Consultation Response from KC, Highways Development Management		
2021/91208 Former Pizza Hut Restaurant, Centre 27 Business Park, Bankwood Way, Birstall, Batley, WF17 9TB		
Installation of drive-thru lane and associated engineering works, alterations to car parking and servicing arrangements and associated changes to landscaping. Demolition of existing enclosed yard and provision of replacement bin store, minor alterations to the building and elevations including recladding		
Date Responded: 20/04/2021	Responding Officer: Zack Turner	Responding Ref: K13-9/1

2021/91208

This application is at Former Pizza Hut Restaurant, Centre 27 Business Park, Bankwood Way, Birstall, Batley. The proposal is for the installation of a drive-thru lane and associated engineering works, alterations to car parking and servicing arrangements and associated changes to landscaping. Demolition of existing enclosed yard and provision of replacement bin store, minor alterations to the building and elevations including recladding.

P PROPOSED SITE PLAN
PLAN SCALE 1:200 @ A1

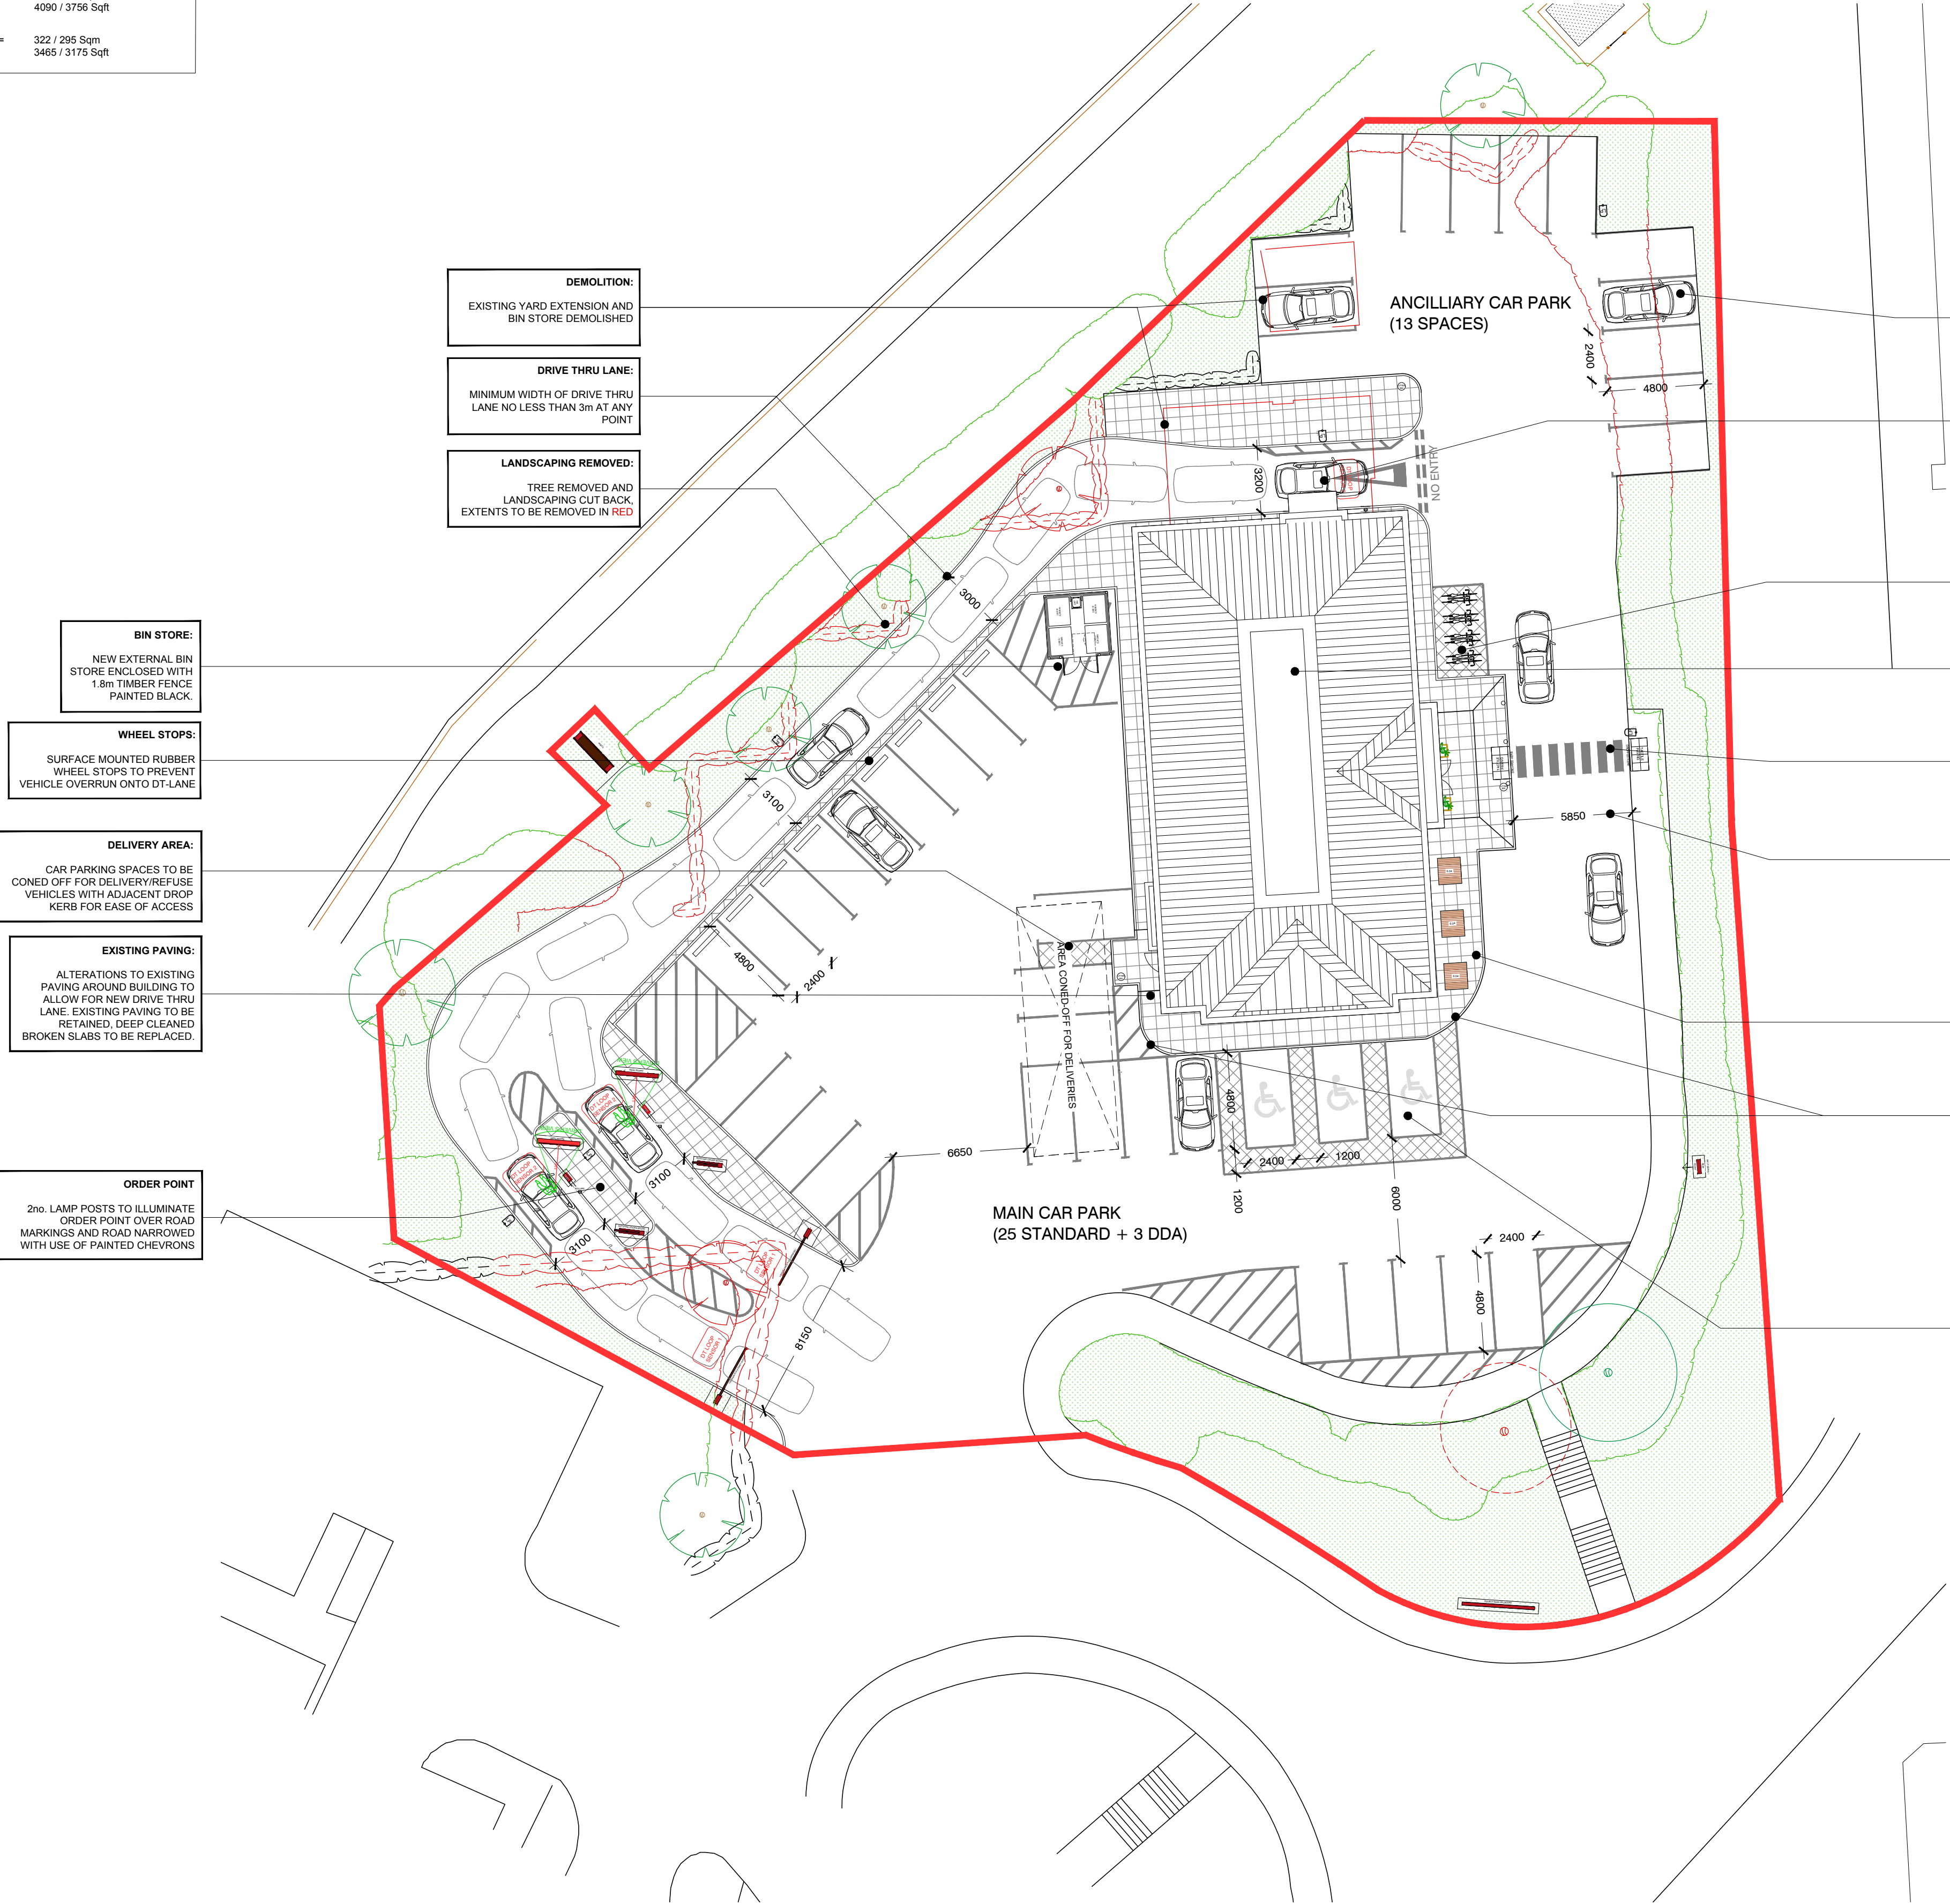
The dimensions for the parking spaces, drive-thru lane, area between parking spaces and access are currently below standards and need amending to the following as a minimum.

Parking space – 2.4m x 4.8m

Disabled parking space – 2.4m x 4.8m with a 1.2m area to the sides and rear of each space.

Drive-thru lane – 3m

Area to the rear of each parking space – 6m

Access – 5.5m

HDM requests that these dimensions are demonstrated on a plan.

Information needs to be provided on the number of covers for the proposed fast-food shop and this should be shown on a plan.

HDM are unable to support the application in its current form and requests an amended plan for a proper assessment of the proposals.
